Medworth Energy from Waste  
Combined Heat and Power Facility

PINS ref. EN010110  
Document Reference: Vol 9.14  
Revision 1.0  
Deadline: 1  
March 2023

**Statement of Common Ground  
between Medworth CHP Limited  
and King's Lynn Internal Drainage  
Board (DRAFT)**

Figure 12.3i
Water environment (Proposed Development)

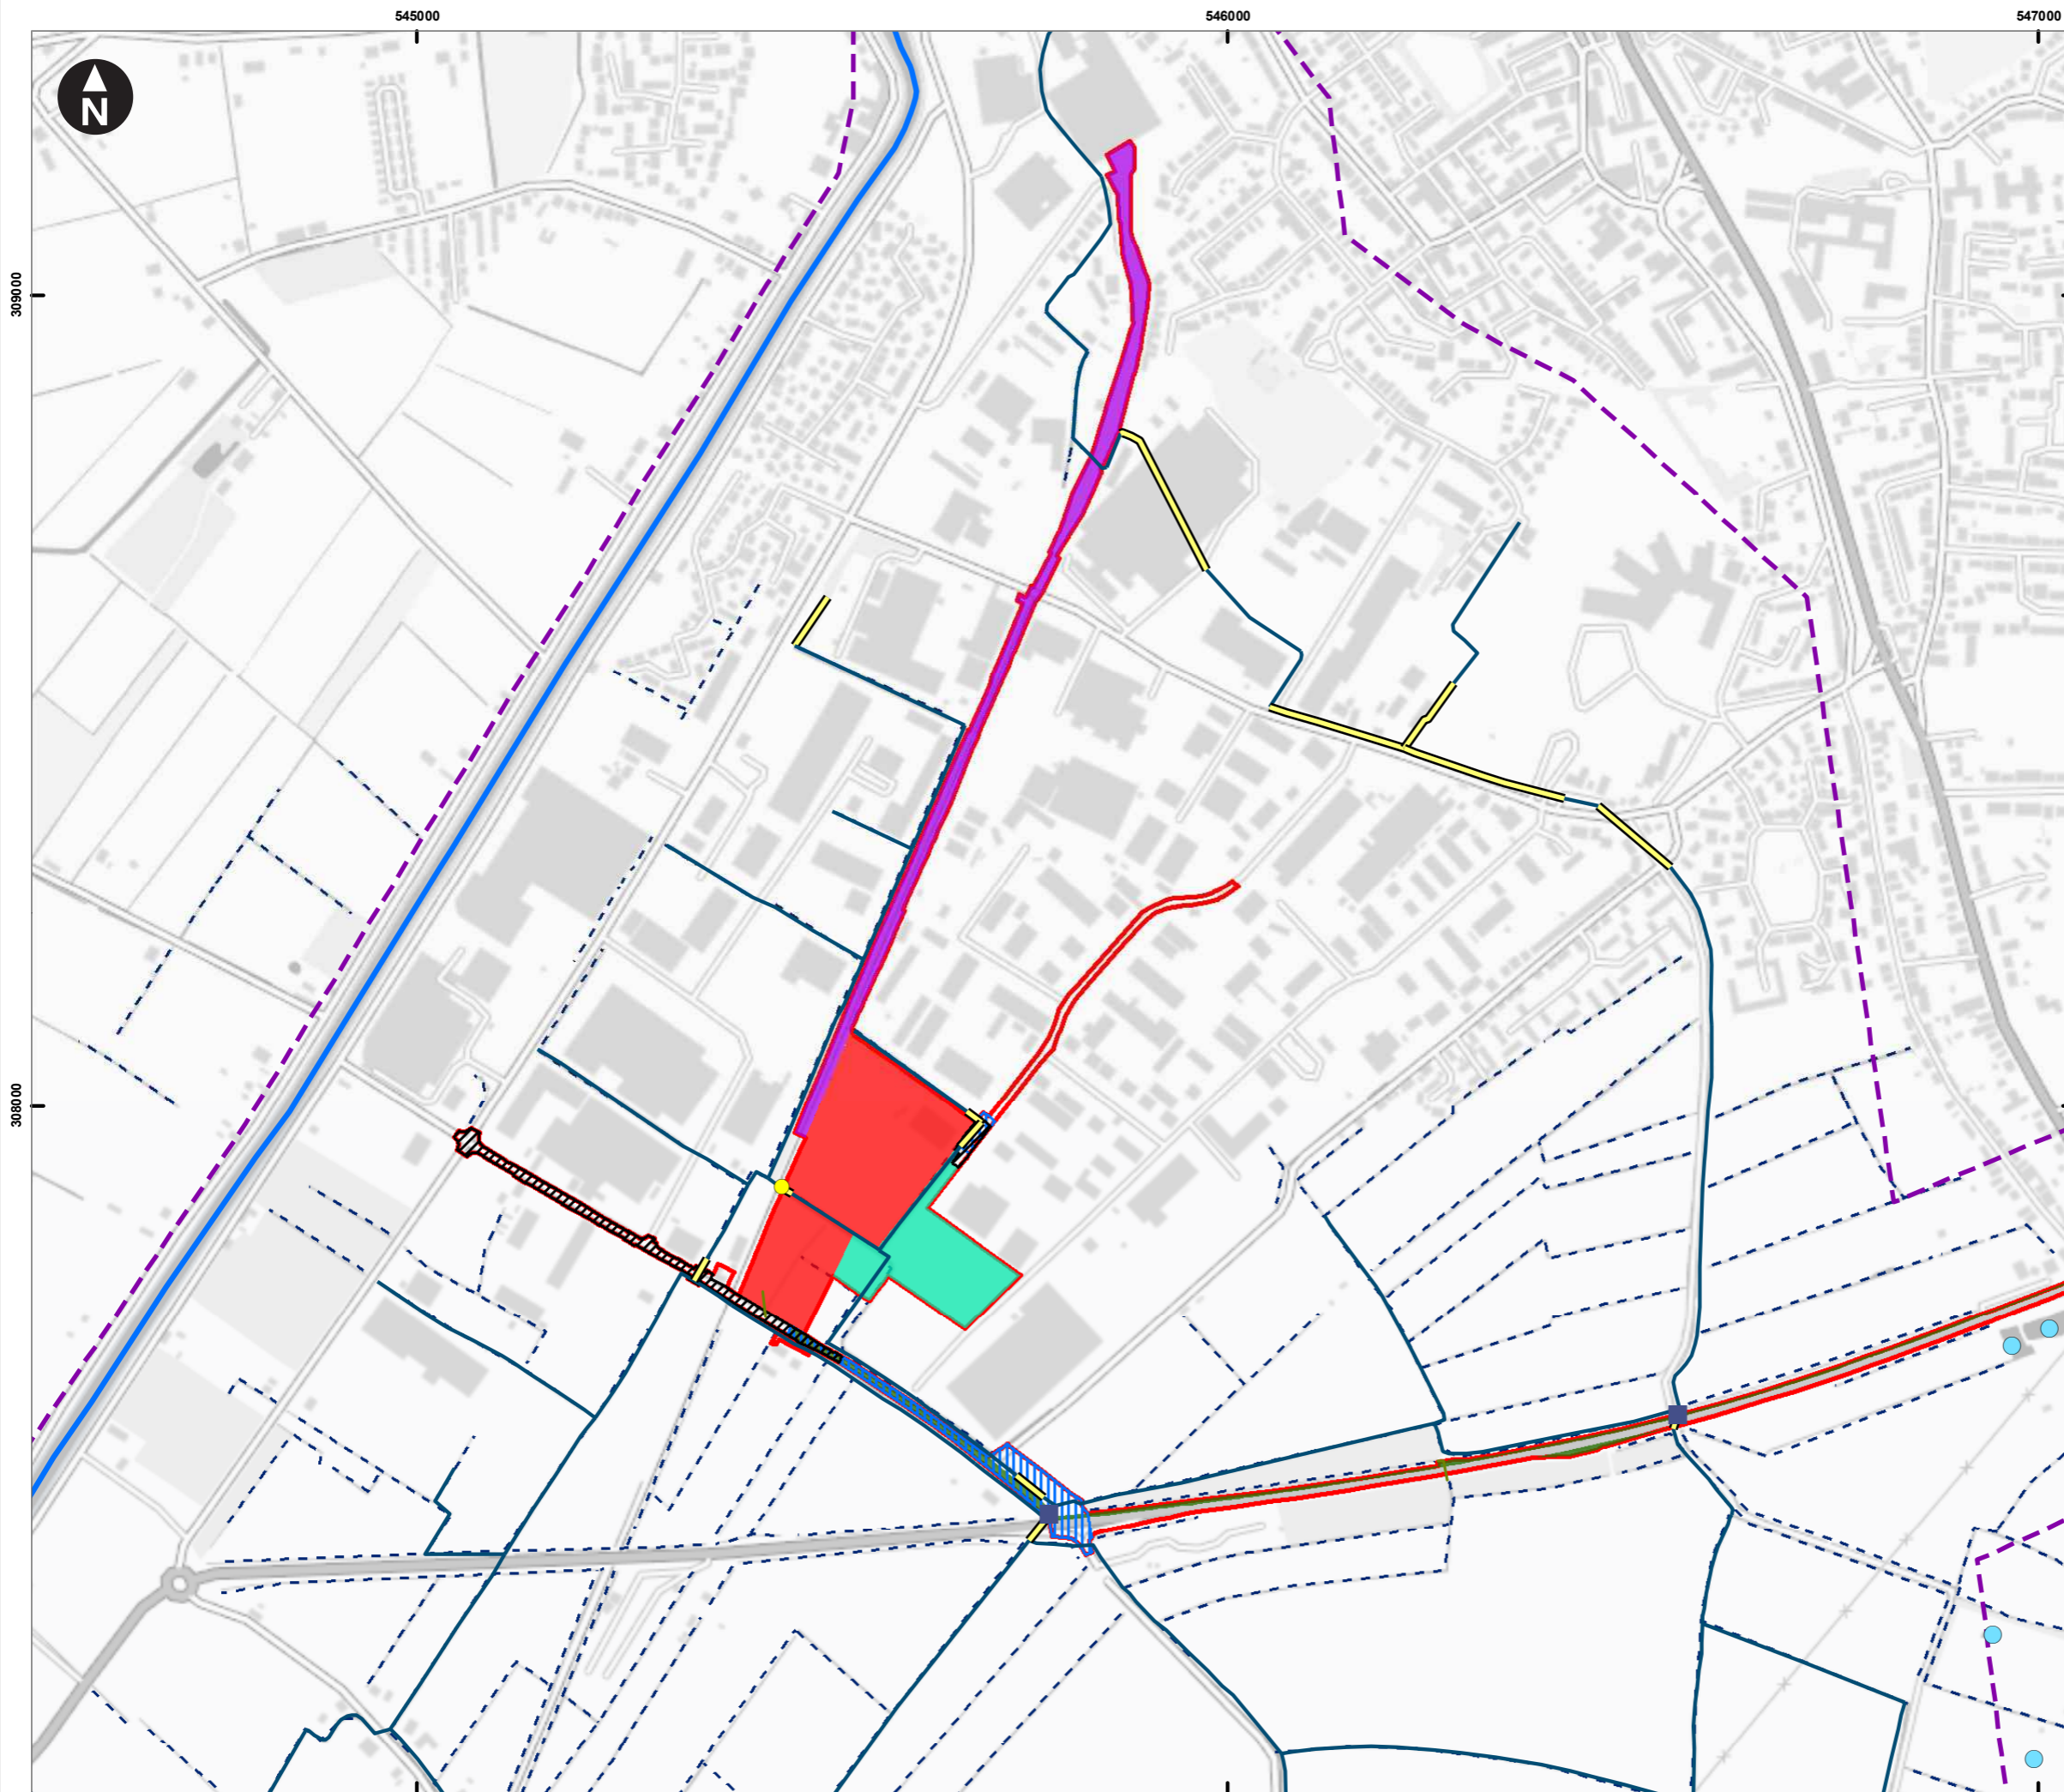
3.3.3	The underground cable route (Grid Connection) will only cross three KLIDB maintained watercourses. These are accurately illustrated on <b>Figure 12.3i: Water environment (Proposed Development) (Volume 6.3) (paragraph 12.5.20 ES Chapter 12 Hydrology Volume 6.2)</b> .		Update Figure 12.3i to replace “adopted” with “KLIDB maintained” within the figure key
